Recommendation Report for Planning Permission for Works or Extension to a Dwelling

REF NO: FP/112/21/HH

LOCATION: 11 Culver Road
Felpham
PO22 7EF

PROPOSAL: Loft conversion and extension

PROPOSED ELEVATIONS

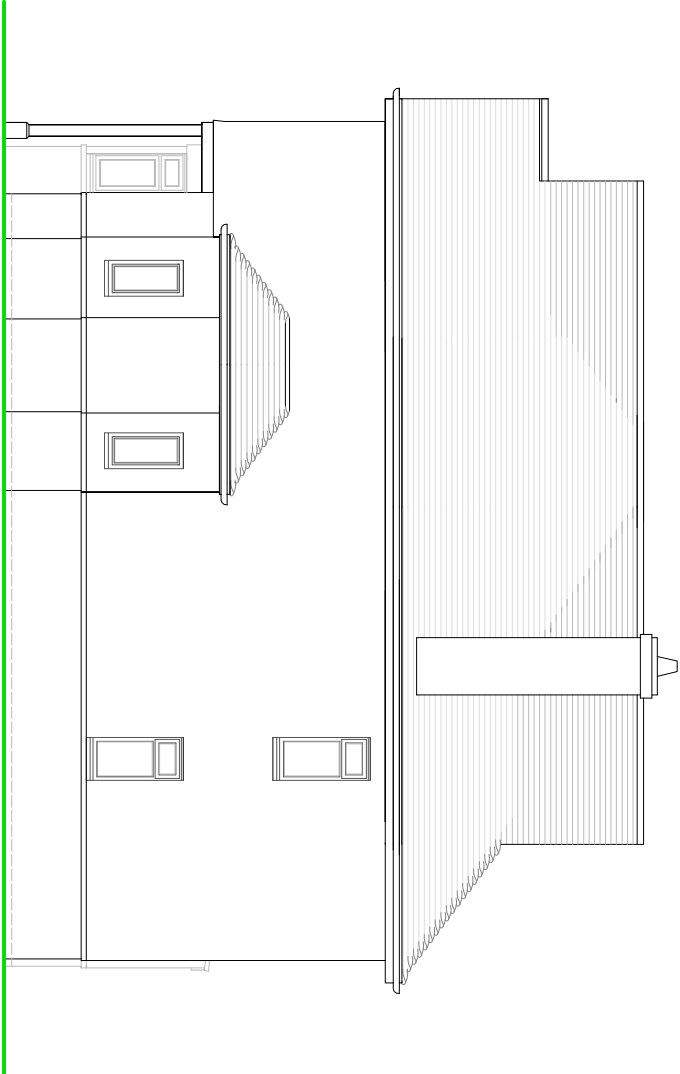
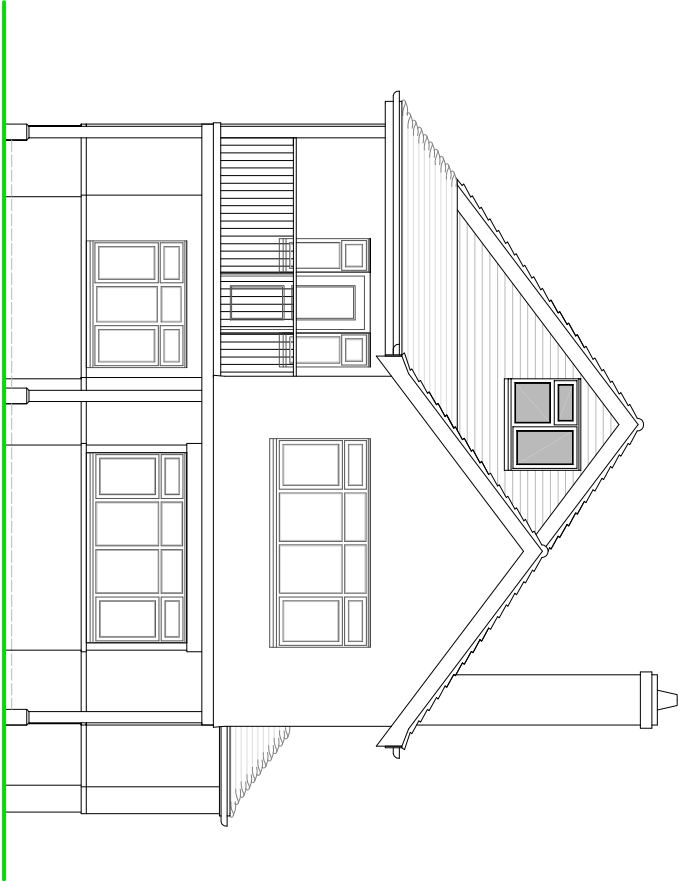
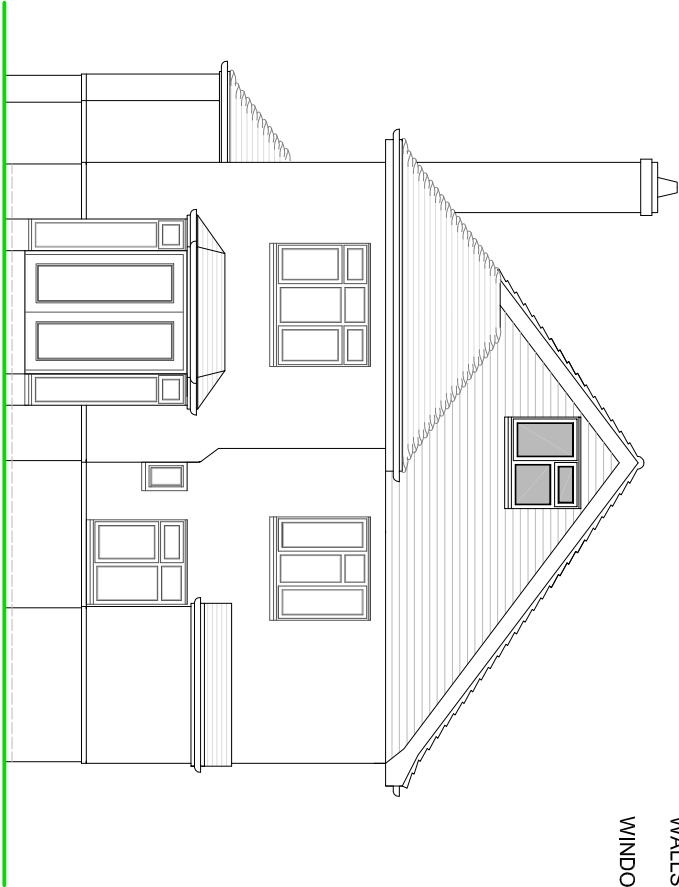
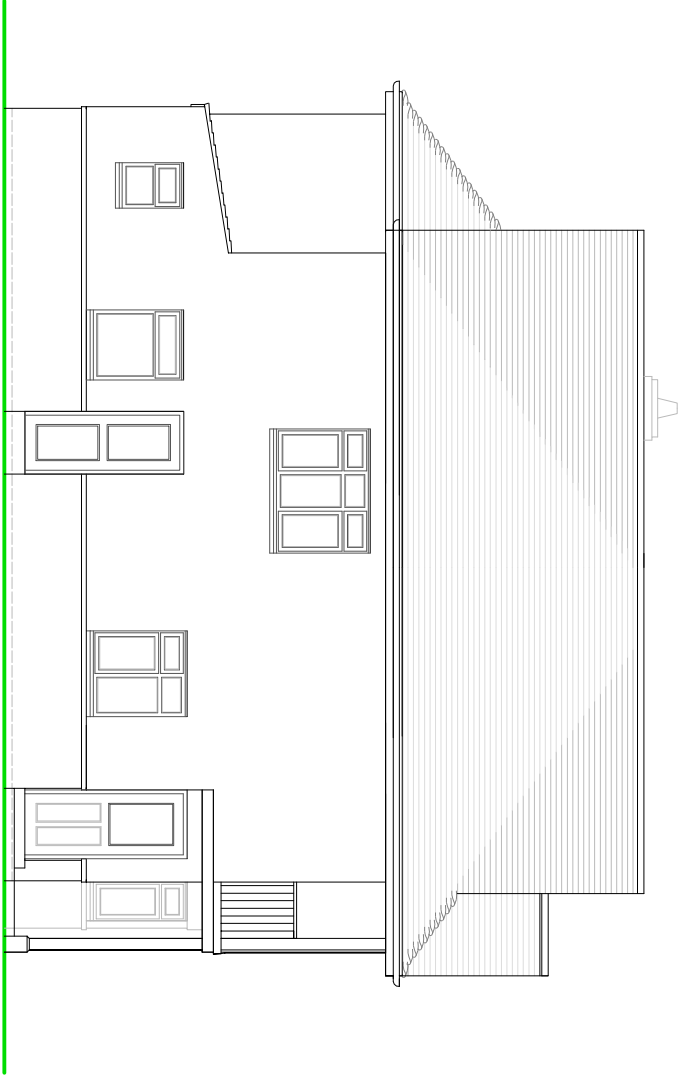
The proposals are for a loft conversion with hip to gable main roof extensions to front (south) and rear (north). There will also be enlarging of existing front and rear roof windows (1 per elevation).

Due to the siting of extension to the front (south) roof elevation it will be highly visible from the street scene. Whilst the design adds some bulk to the front roof elevation, the pitched roof design is in-keeping with the existing property and will not adversely impact the street scene or the surrounding character so complies with policy D DM1 of the Arun Local Plan.

Due to the siting of extension to rear (north) roof elevation it will be significantly less visible from the street scene. Whilst the design will give rise to additional bulk to the rear and be viewable from the sides, the pitched roof design is similarly in keeping with the existing property.

dwelling. Whilst the hip to gable extensions do not comply adding additional bulk, the size is in keeping with the existing property and scale does not adversely impact the surrounding character so is acceptable. It also states that the roof extensions must preserve neighbouring amenity by avoiding designs which result in excessive visual intrusion and/or the blocking of light into surrounding properties. The proposals will have a minor impact on light impact to neighbouring properties so is acceptable. It also states roof extensions associated with loft conversions can play a valuable role in increasing the efficiency of a building's land use while ensuring appropriate amenity for occupants. Roof extensions should be located in discreet positions on rear elevations wherever possible. Whilst the roof extension to front does not comply, the design is in keeping and does not adversely harm the character so is acceptable.

The proposed materials will match the existing dwelling and comprise of plain clay tiles to the pitched roof, plain tile hanging to new gable walls, and white UPVC double glazed windows so comply with policy D DM1 and D DM4 of the Arun Local Plan and policy ESD1 of the Felpham Neighbourhood Development Plan.

Due to the window enlargement to front (south) roof elevation there is increased risk to overlooking to neighbouring properties to south however due to gap of around 8.0m remaining to south boundary and location of road to south there is no adverse harm to overlooking to south so is acceptable. Also, the enlargement concerns an existing window from which views can already be taken.

Due to the window enlargement to the rear (north) roof elevation there is increased risk to overlooking to neighbouring properties to east however due to building line to east positioned forward and gap of around 5.2m remaining to east boundary there is no adverse harm to overlooking to east. Also, the enlargement concerns an existing window from which views can already be taken. Due to large gap of around 18.9m remaining to the rear (northern) boundary there is no adverse harm to overlooking to neighbouring properties to north so is acceptable.
